From: Simon Davis
Sent: 09 November 2021 17:39
To: Nicola Spencer; Hannah Riddle
Subject: SUB PLAN REQUEST - BN/134/21/DOC
Attachments: 18158 Addendum Letter Report Rev2_ISSUE.pdf; 108.5009.505.E.pdf; 108.5009.503.G.pdf; 108.5009.502.F.pdf; 108.5009.504.F.pdf; 108.5009.501.D.pdf; 108.5009.751.B.pdf; 108.5009.705.G.pdf; 108.5009.706.F.pdf; 108.5009.704.A.pdf; 108.5009.703.A.pdf; 108.5009.552.B.pdf; 108.5009.506.F.pdf; 108.5009 - PERMEABLE PAVING 1in100.pdf; Response to Drainage Comments.pdf; 108.5009.703.A.pdf

From: Grace Palmer [REDACTED]
Sent: 01 November 2021 16:35
To: Simon Davis <Simon.Davis@arun.gov.uk>
Subject: RE: Planning Consultation on: BN/134/21/DOC

The engineers have jumped on this round of comments and responded/updated drawings with the typos or missing information to hopefully finalise queries now. See response in blue below for ease and attached updated drawings.

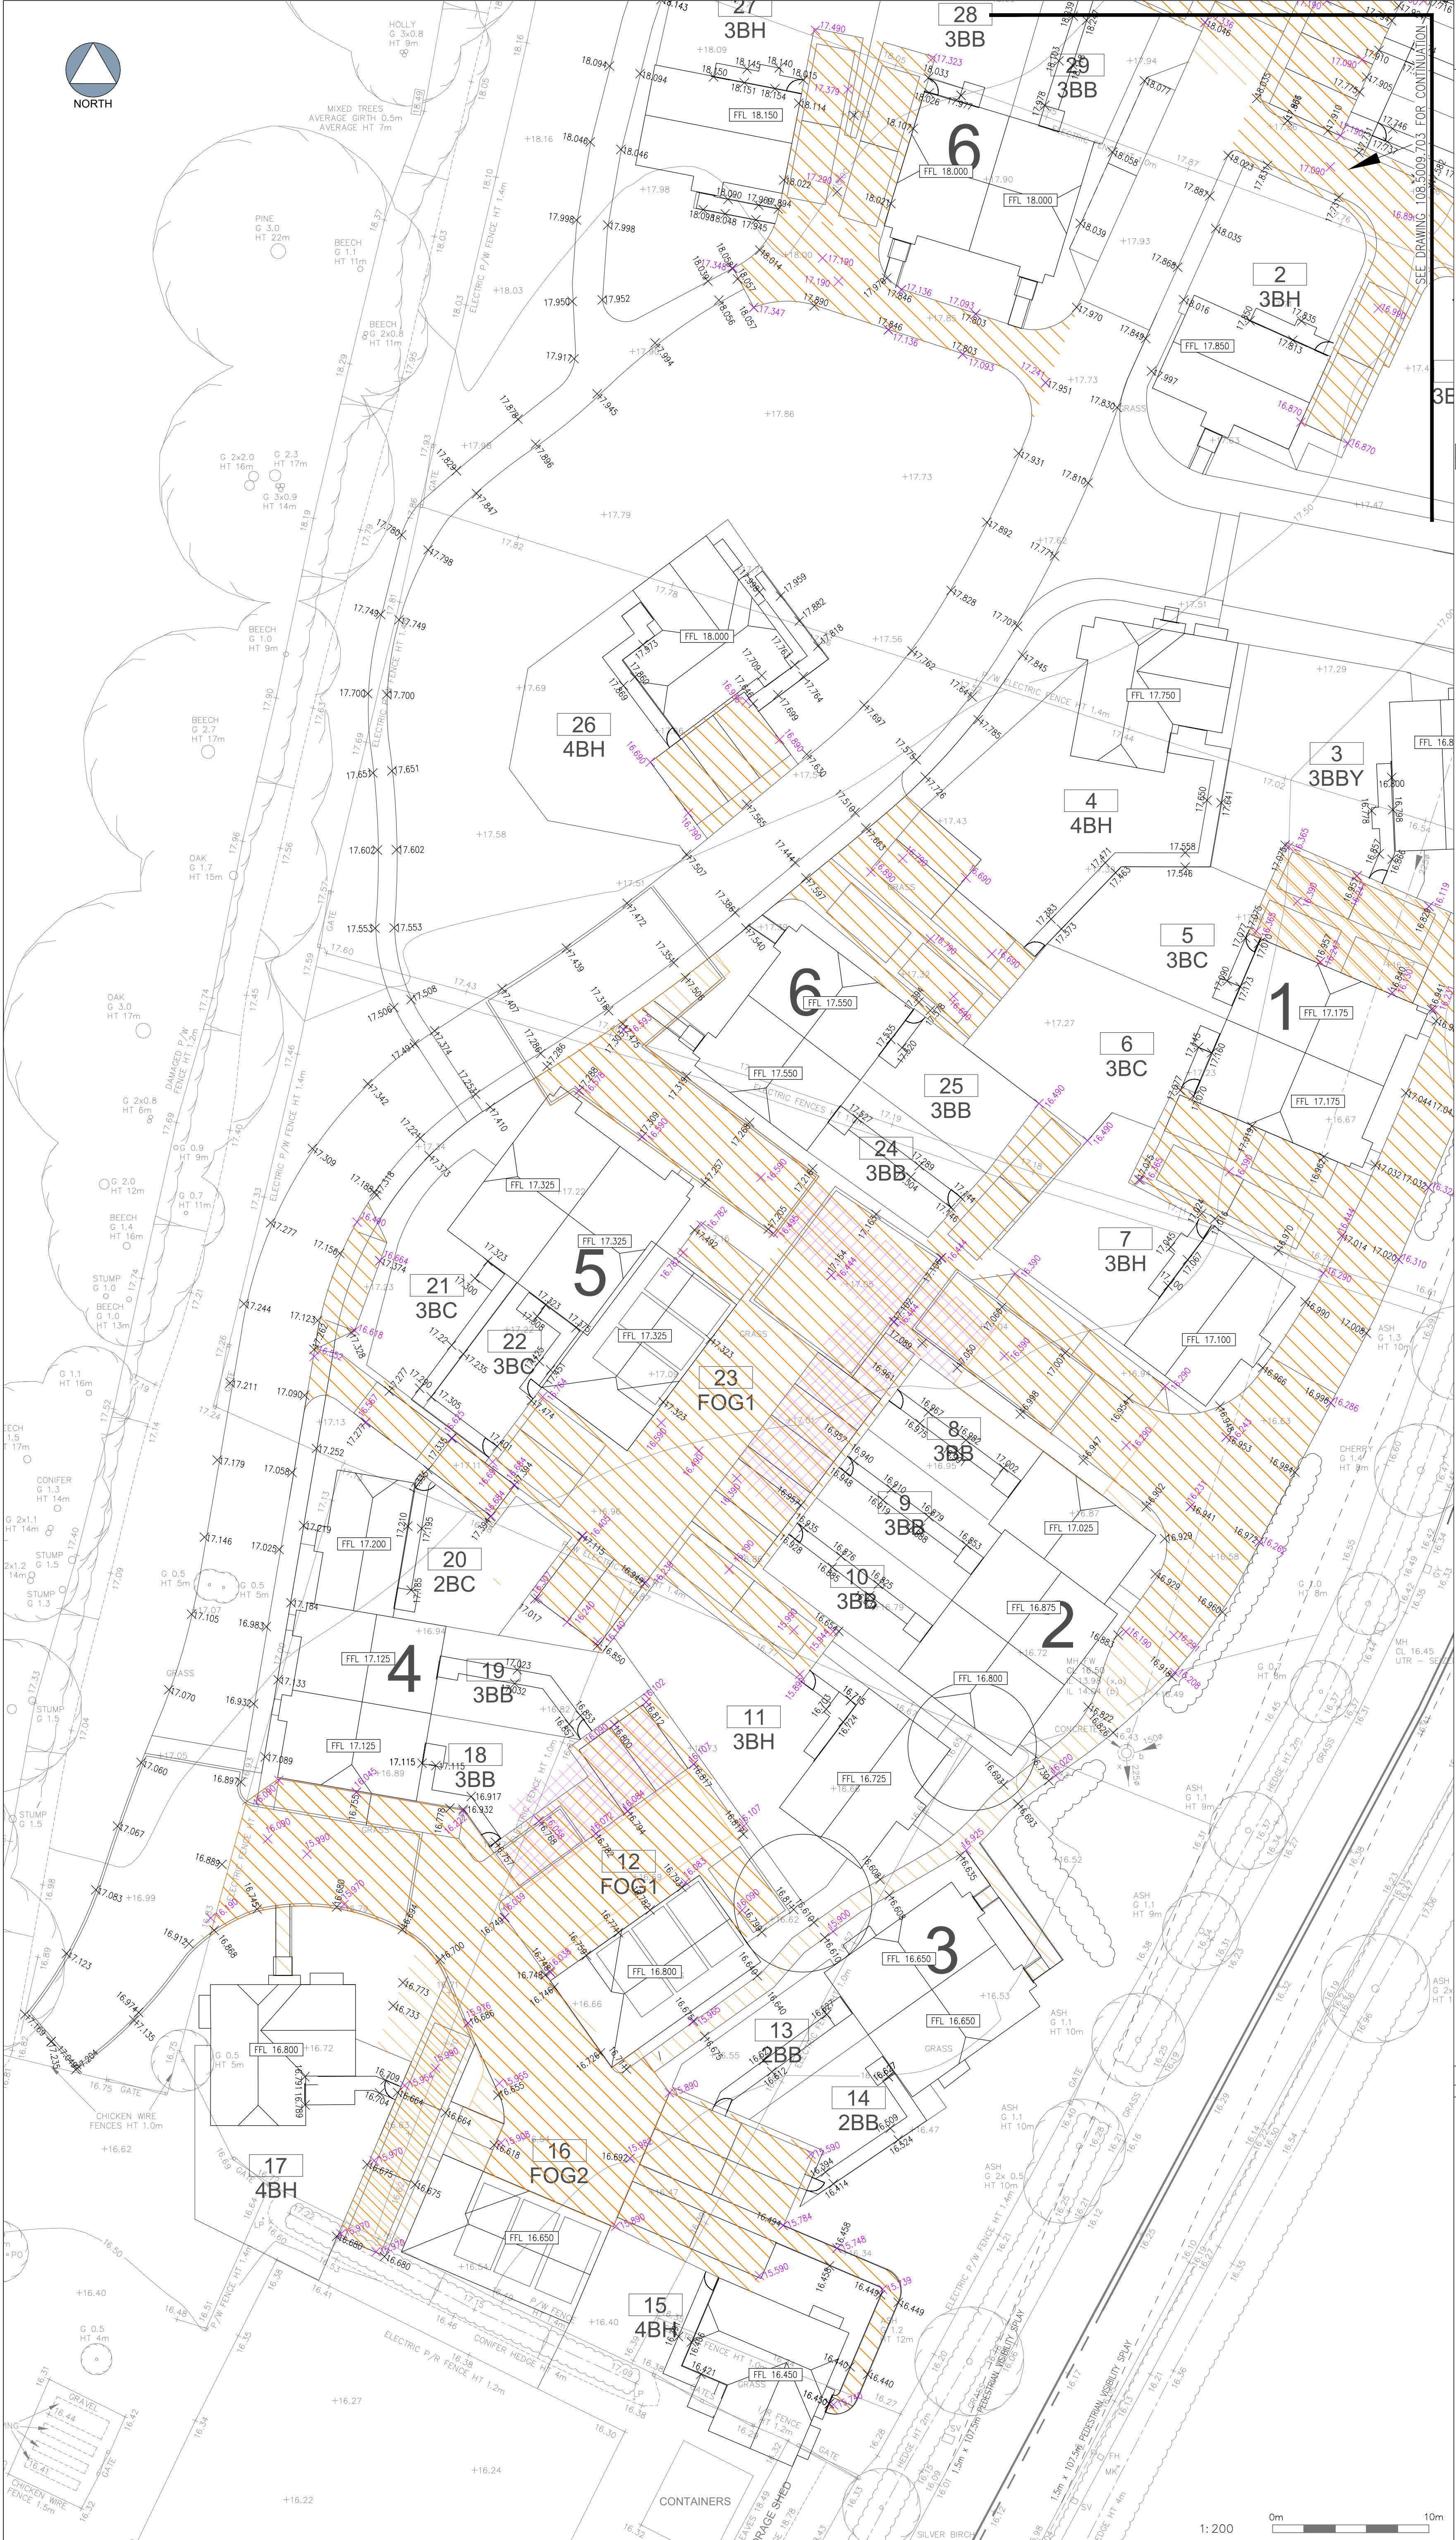
7. Capping layer below type 3 on the permeable paving must state “no fines”. Please also clearly label the base geotextile.

Permeable paving specification updated to state ‘no fines’ on capping layer – drawings 703, 704, 705, 706, 751, 552 and drawings 501-506 updated accordingly

Checked By RW	Checked Date 21.04.21	Drawn By RD	Drawn Date 20.04.21
Client Drawing No.		Scale 1:20	(AT A1 SIZE)
PBA Drawing No. 108.5009.551			Revision F

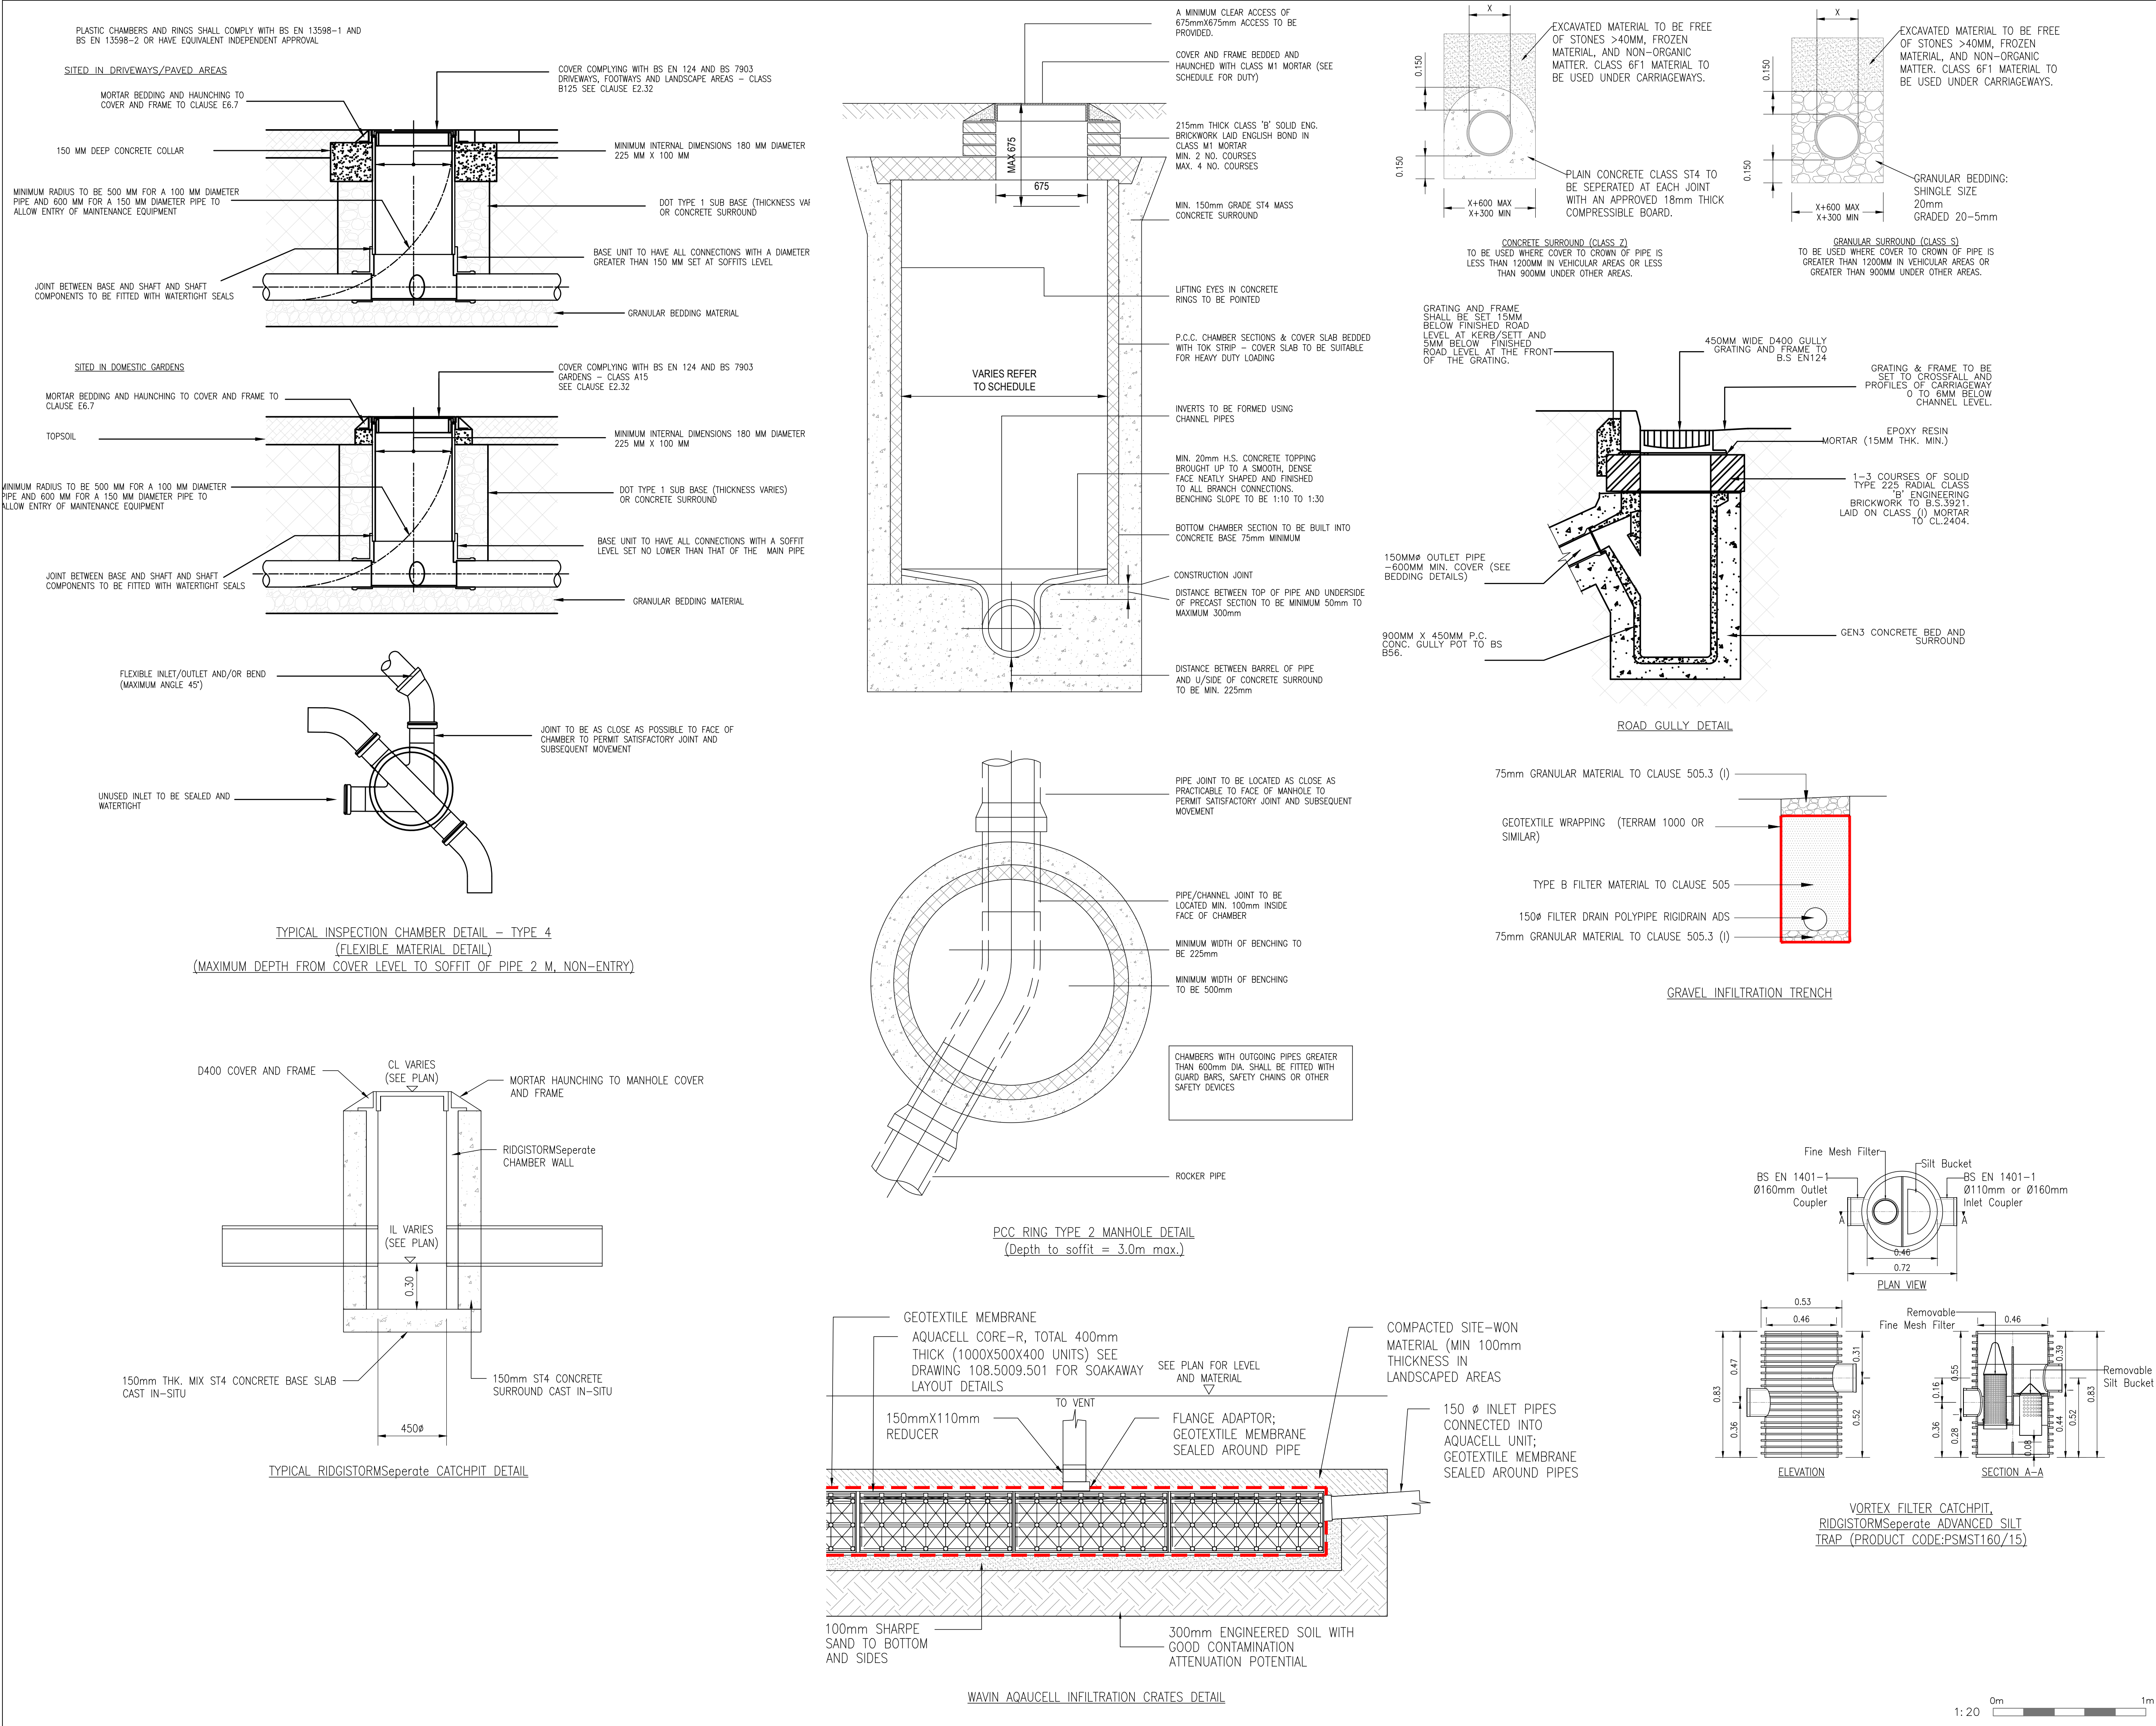
8. The soakaway construction detail needs to be improved. As crate depth varies, the detail should not state total 400mm thick, and should instead state that the depth varies and reference the plans that depth is detailed on. Minimum cover depth should be stated.

9. Please provide a construction detail drawing of granular soakaways.

Note on soakaway construction detail amended to state: *AQUACELL CORE-R 1000X500X400 UNITS, EXACT DEPTH AND AREA OF SOAKAWAYS VARY, SEE DRAWING 108.5009.501 FOR SOAKAWAY LAYOUT DETAILS.*
Drawing 551 updated accordingly

A granular soakaway detail is shown on drawing 551.F
